Ribble Valley Borough Council  
Housing & Development Control

Application no: **3/2022/0637**

Address: **Keepers Cottage Northcote Road Langho BB6 8BD**

Proposal: **Proposed alterations and extensions to existing B&B premises to create an 8 bed boutique hotel with on-site parking and improved landscaping.**

**A1.2**

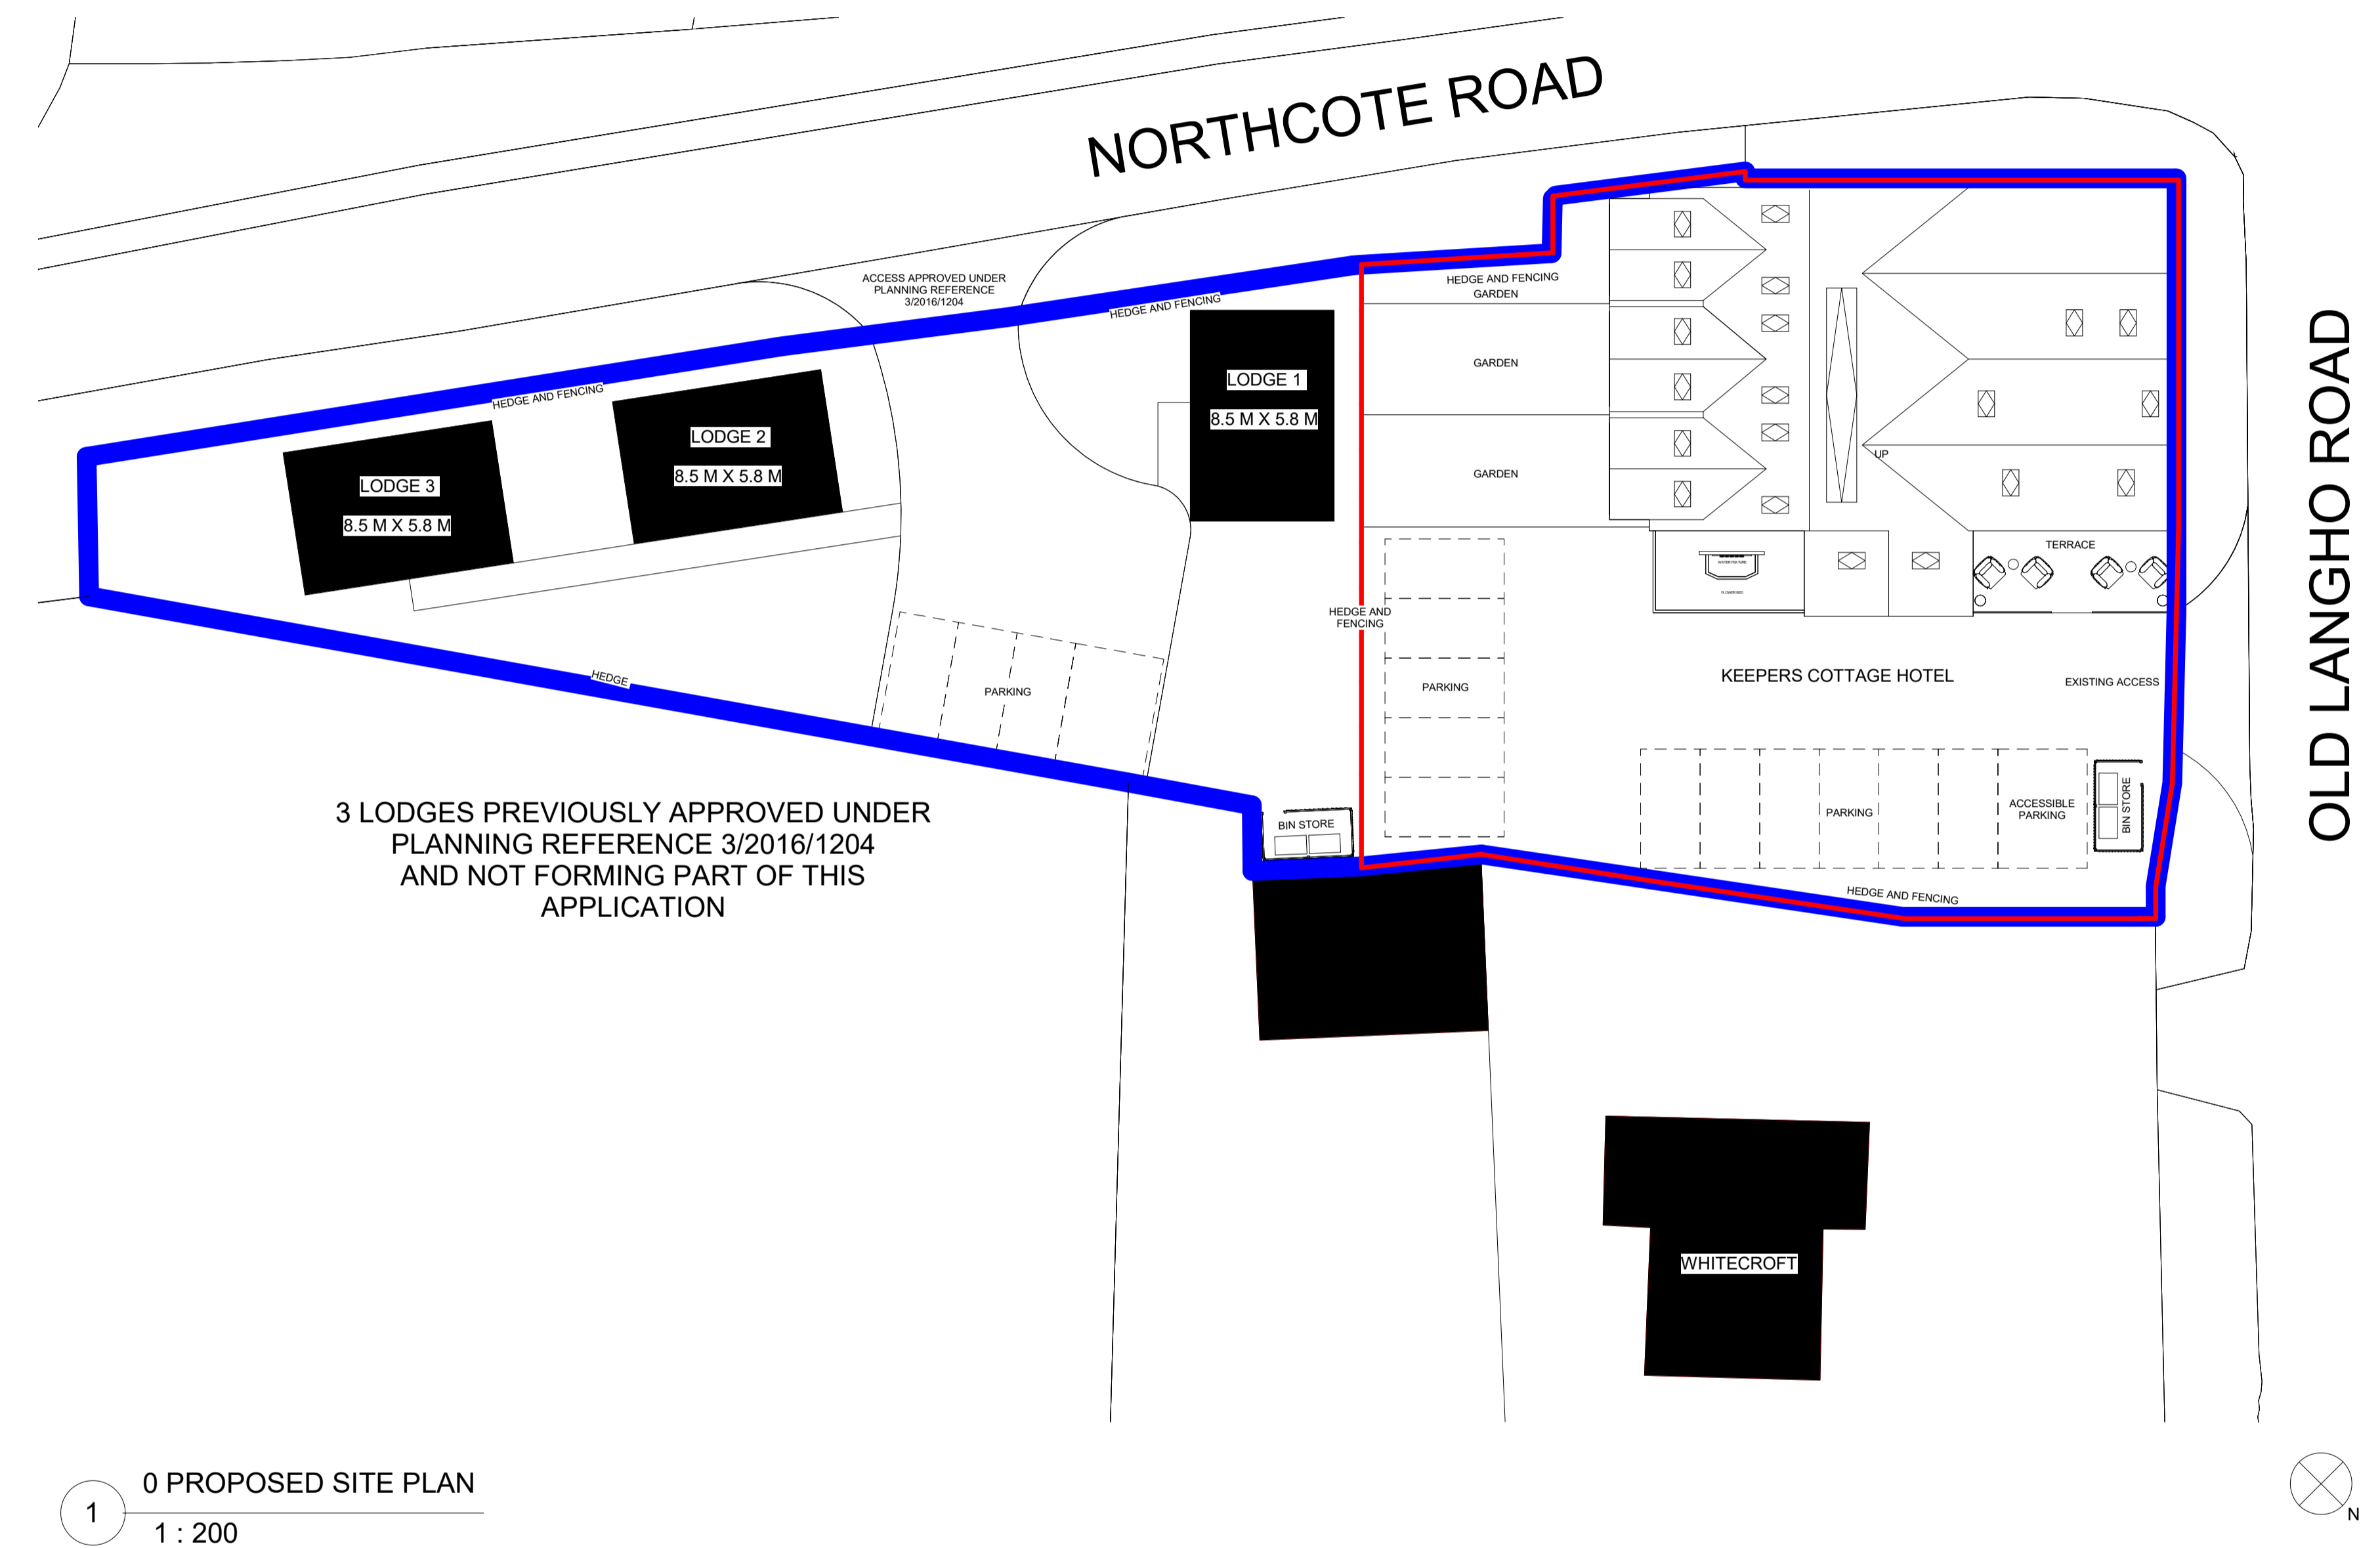
The LHA have reviewed Peter Hitchen drawing number A1.2 titled "Proposed Site Plan," and are aware that the access to the proposed 8 bed boutique will remain as existing. The LHA have reviewed the site access and have no objection to the use of the access. This is because the access already served the previous Bed and Breakfast use, and the proposal is only adding an additional bedroom to the site. Therefore, there is only a minor intensification of use which allows the LHA to have no objection to the use of the access.

The LHA have reviewed Peter Hitchen drawing number A1.2 titled "Proposed Site Plan" and are aware that the site will provide 12 car parking space for the 8-bed hotel. This complies with the LHAs parking guidance as defined in the Joint Lancashire Structure Plan and so the LHA have no further comments to make.

The LHA will however request that some type of cycle storage facility is provided on site and a minimum of one car parking space has an electric vehicle charging port to promote sustainable transport.

1. No part of the development hereby permitted shall be occupied until such time as the access arrangements shown on Peter Hitchen drawing number A1.2 have been implemented in full.

3. The development hereby permitted shall not be occupied until such time as the parking and turning facilities have been implemented in accordance with Peter Hitchen drawing number A1.2. Thereafter the onsite parking provision shall be so maintained in perpetuity.

4. Prior to the first occupation a minimum of one car parking space implemented in accordance with Peter Hitchen drawing number A1.2 shall have an electric vehicle charging point. Charge points must have a minimum power rating output of 7kW, be fitted with a universal socket that can charge all types of electric vehicle currently.

5. No building or use hereby permitted shall be occupied or the use commenced until a cycle storage plan for the commercial use has been submitted to the Local Planning Authority, in consultation with the Local Highway Authority. These cycle facilities shall thereafter be kept free of obstruction and available for the parking of bicycles only at all times.
